TO:	Helen Donaldson, Senior Planner	DATE:	9/5/2018
FROM:	Michael Guethle, PE; Ryan Wingard, PE	PROJECT NO.:	13982B
SUBJECT:	St. John St. - 222; MMC Parking Garage (PL-000207-2018)

Wright-Pierce has reviewed the Level III Site Plan Application information provided for the Employee Parking Garage redevelopment proposed at 222 St. John Street, including the responses to initial and secondary review comments. The project will include redeveloping an existing parking lot into a nine-level parking garage with approximately 2,400 parking spaces; redeveloping another existing parking surface to provide a pedestrian access and vehicle access to levels 1-8 of the building; and redeveloping a third parking surface to provide 52 additional spaces of surface parking. Off-site improvements to St. John Street and D Street are also included in the proposed work. The work will reduce the total impervious surface area on the property.

GRADING & DRAINAGE PLAN - 2

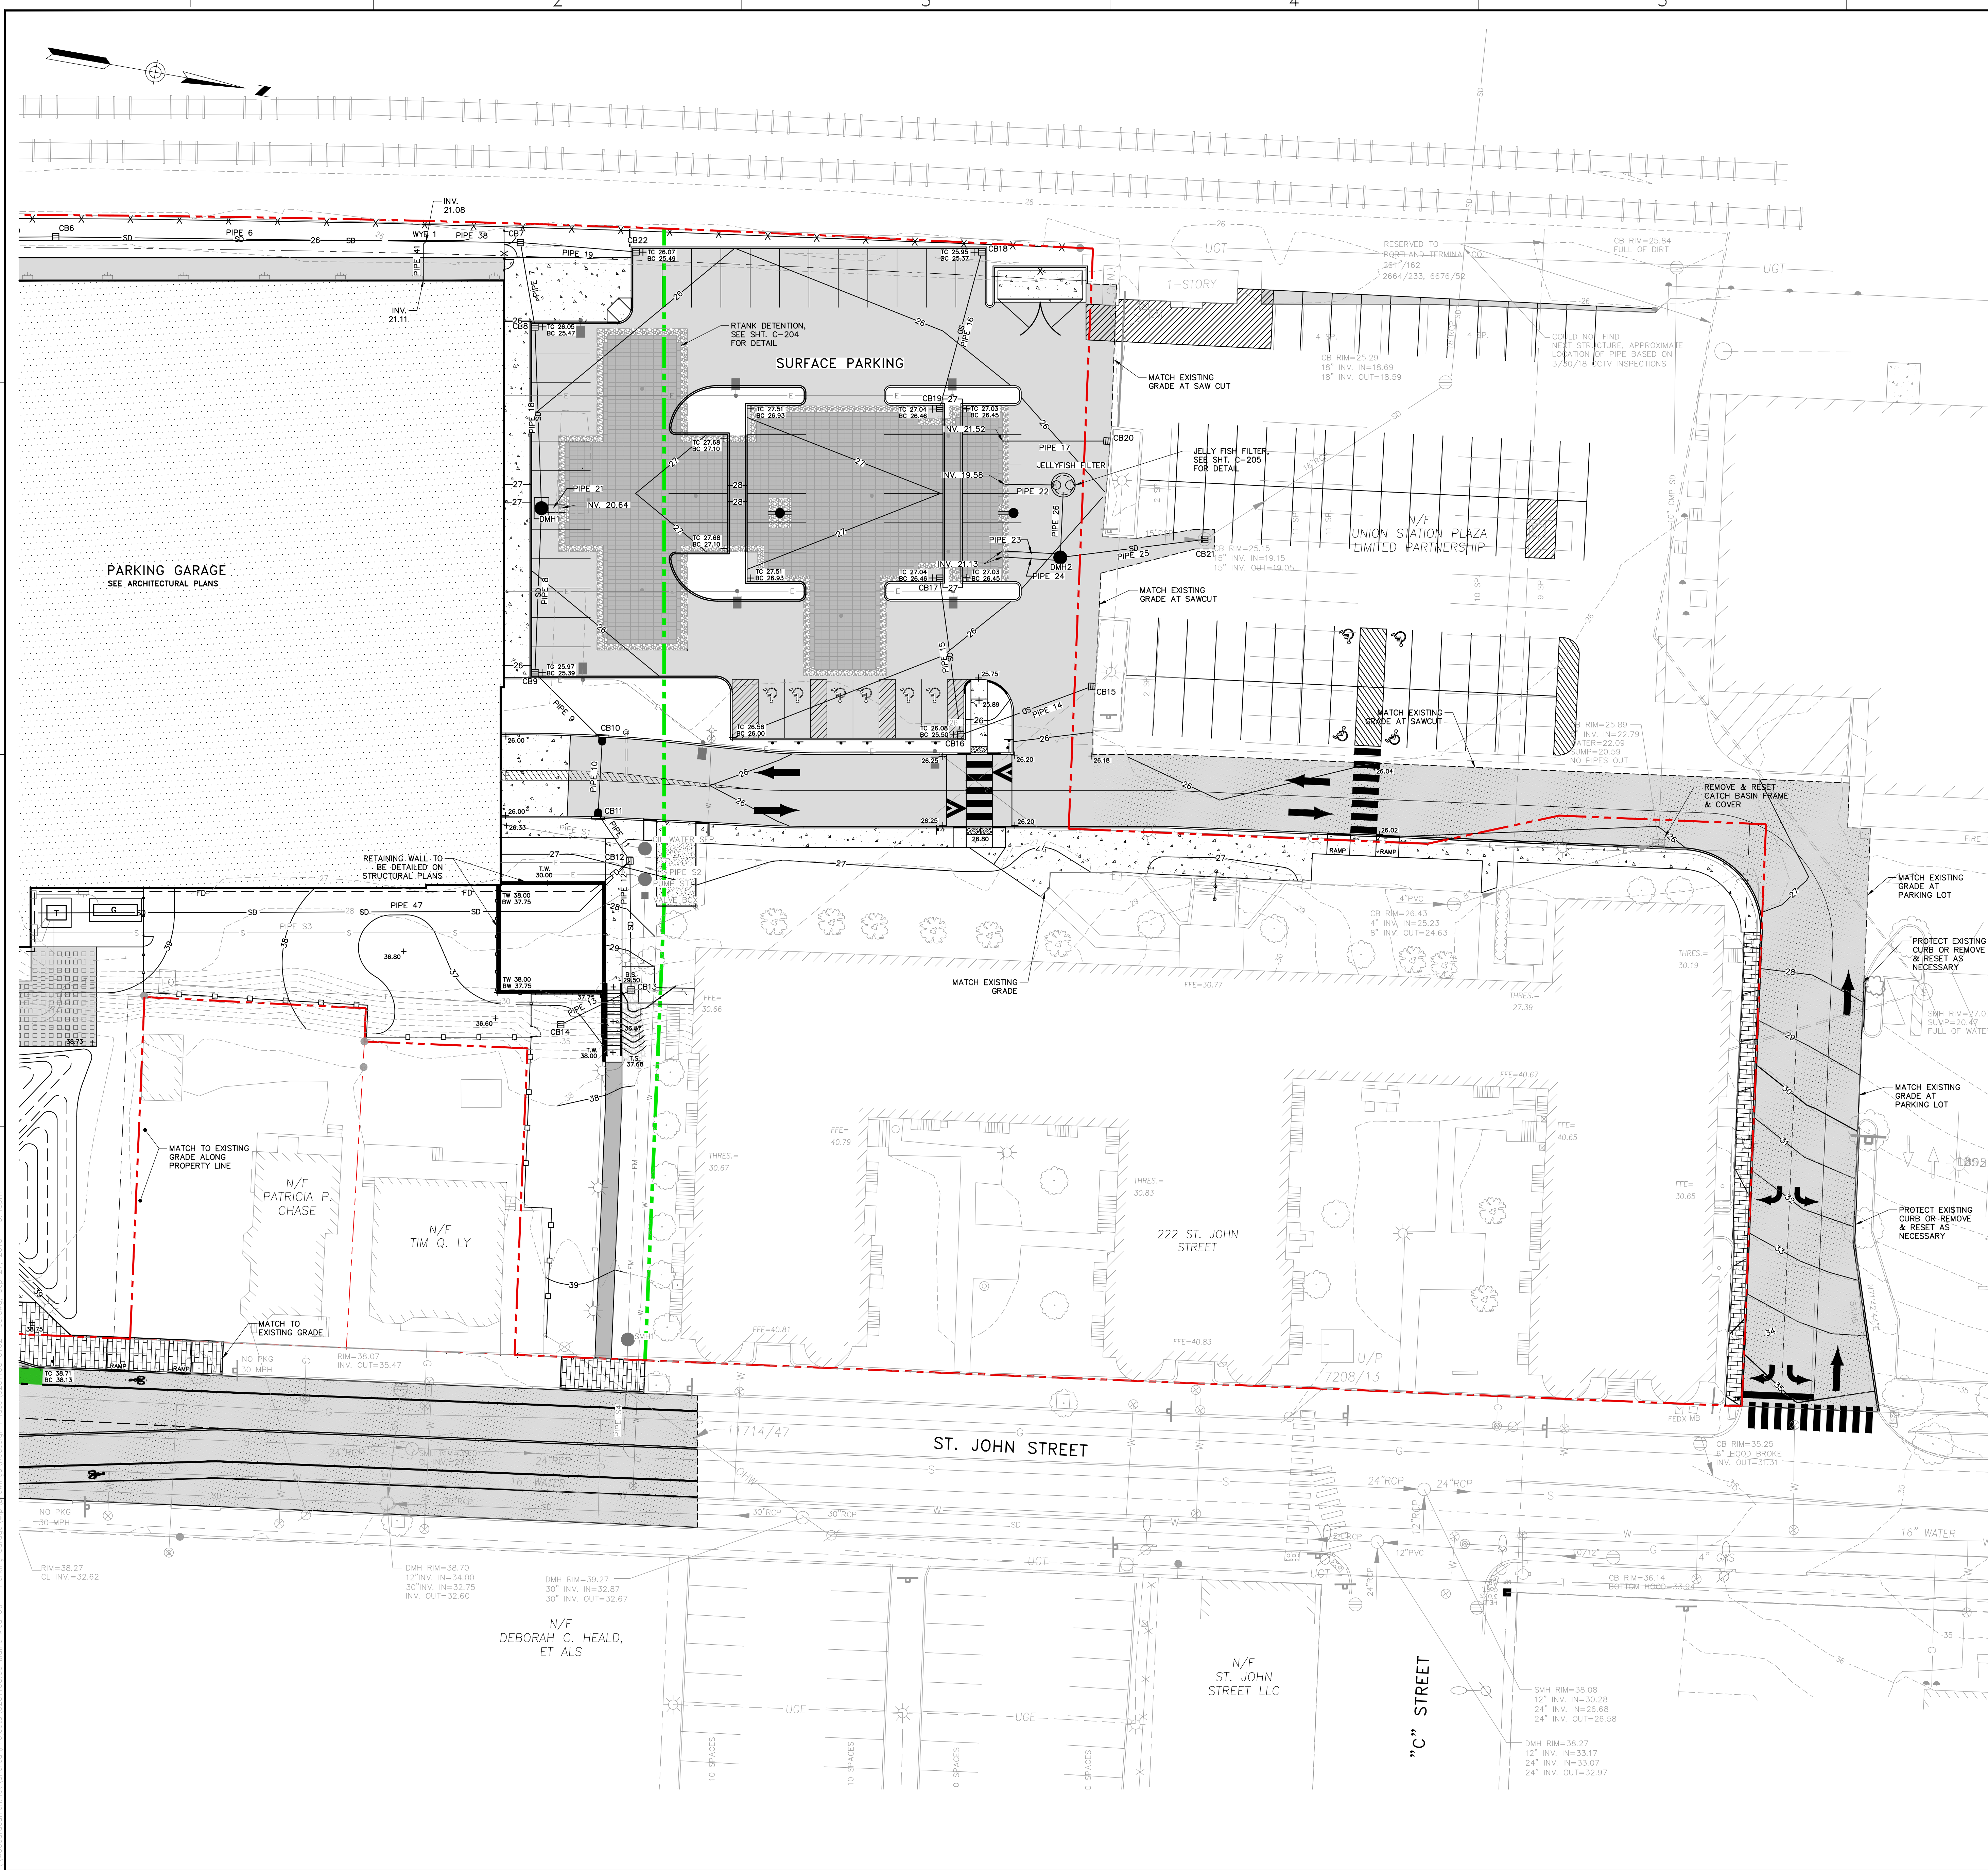
- a. Grading review identified that Pipe 14 between CB15-CB16 has a negative slope. On C-103, the Pipe Table reflects this change to a positive slope, but the Structure Table indicates a negative slope between basins. Please revise.
- b. The applicant has provided a note indicating that crosswalks will not exceed a 2% cross-slope. No further action necessary.
